**APPROVED**  
 Limited building only review  
 Permit holder responsible for full compliance with the code

JOB NUMBER	B-1815928
CAD FILE NAME	PRELUDE-L
ISSUED	11-08-17
REVISED	11-16-17
	09-21-18

**PRELUDE**  
**H&H HOMES**

TITLE  
 UPPER FLOOR PLAN

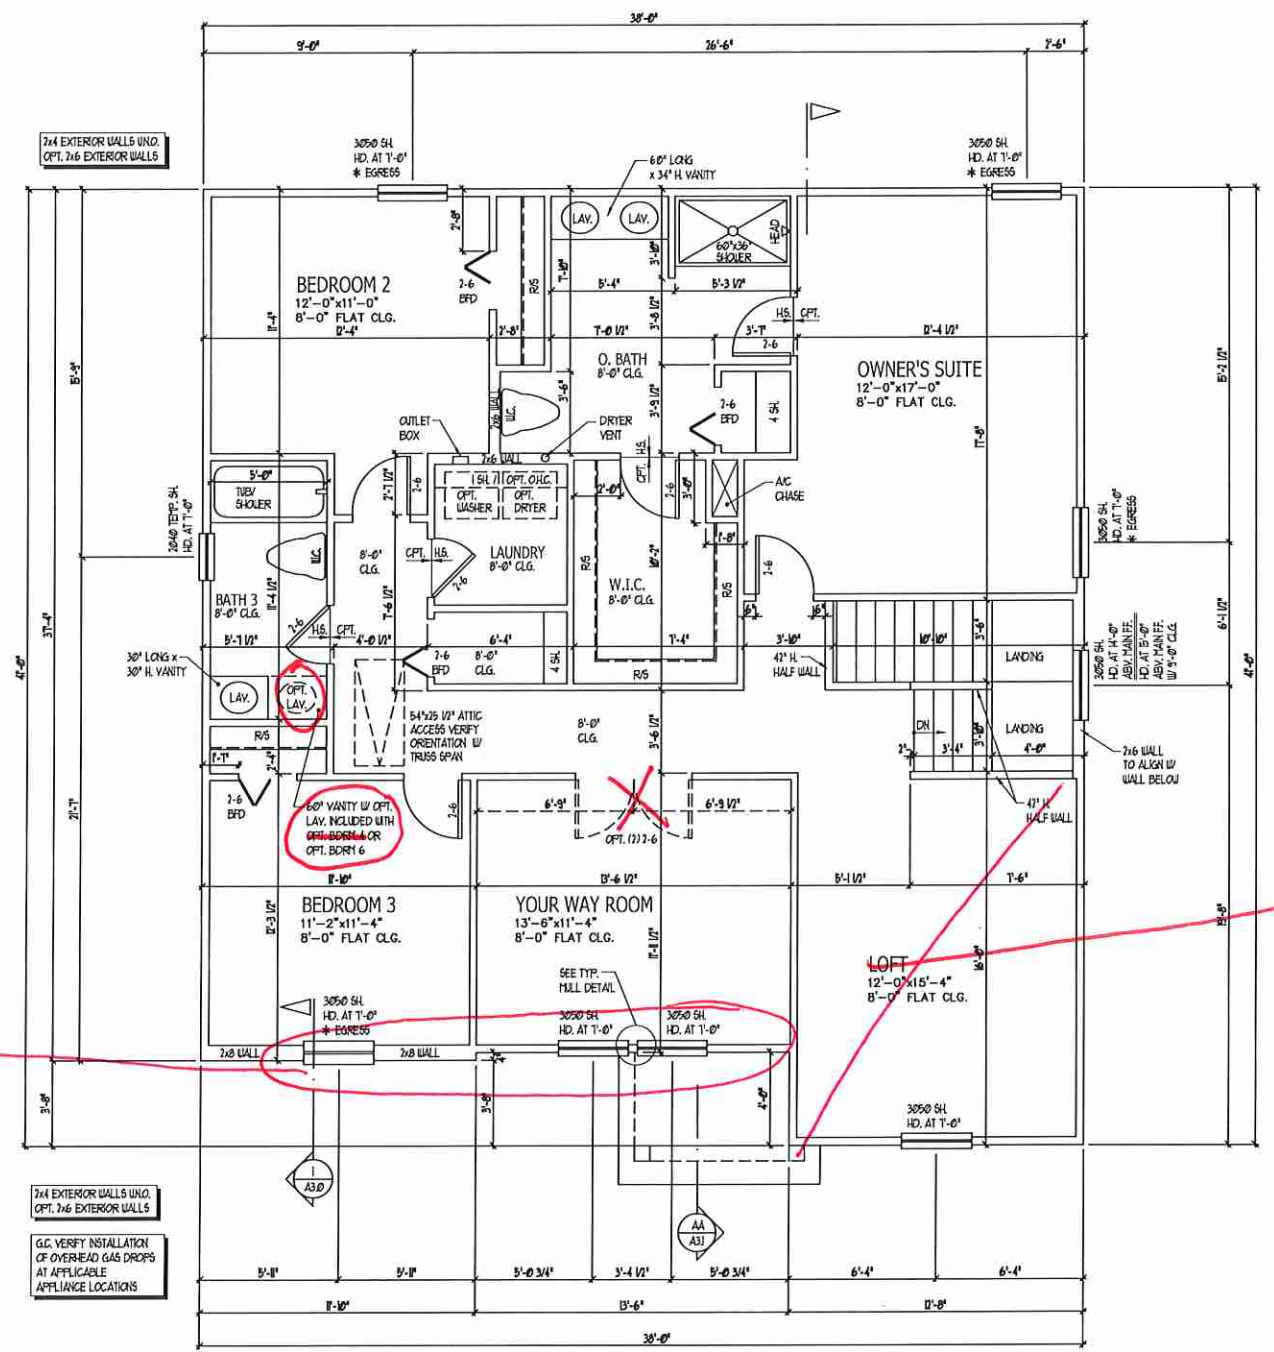
*Beeds bath 3*

*Per elevation C*

SHEET  
**A2.1**

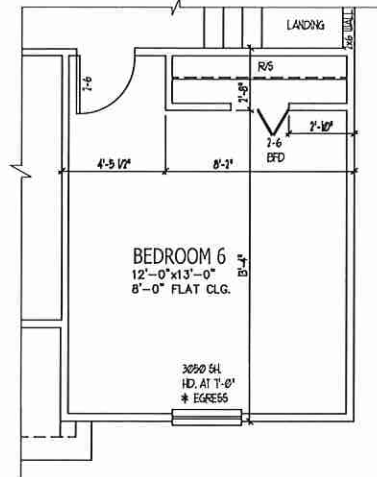
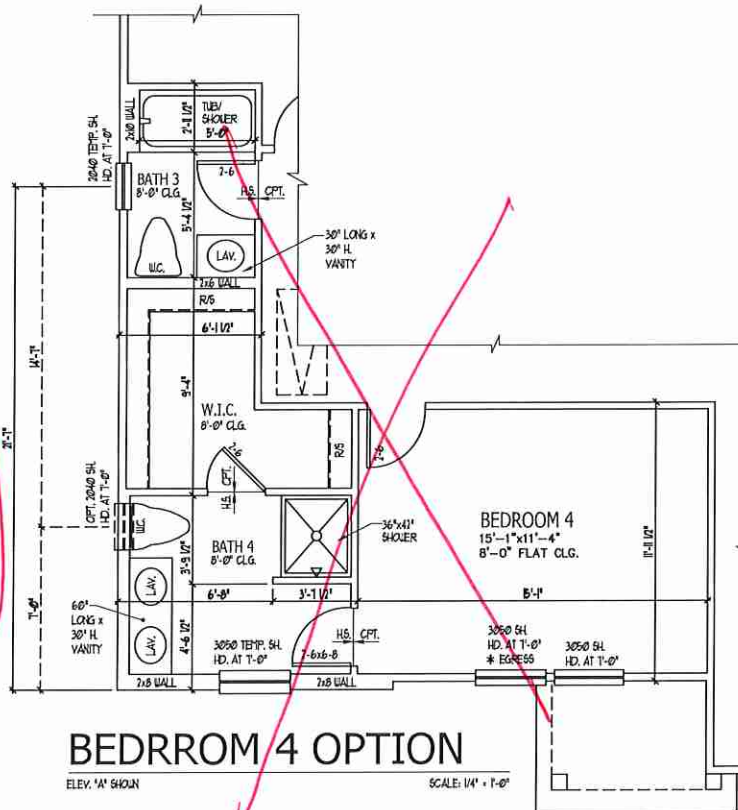
*Per elevation C*

*Bed 6*
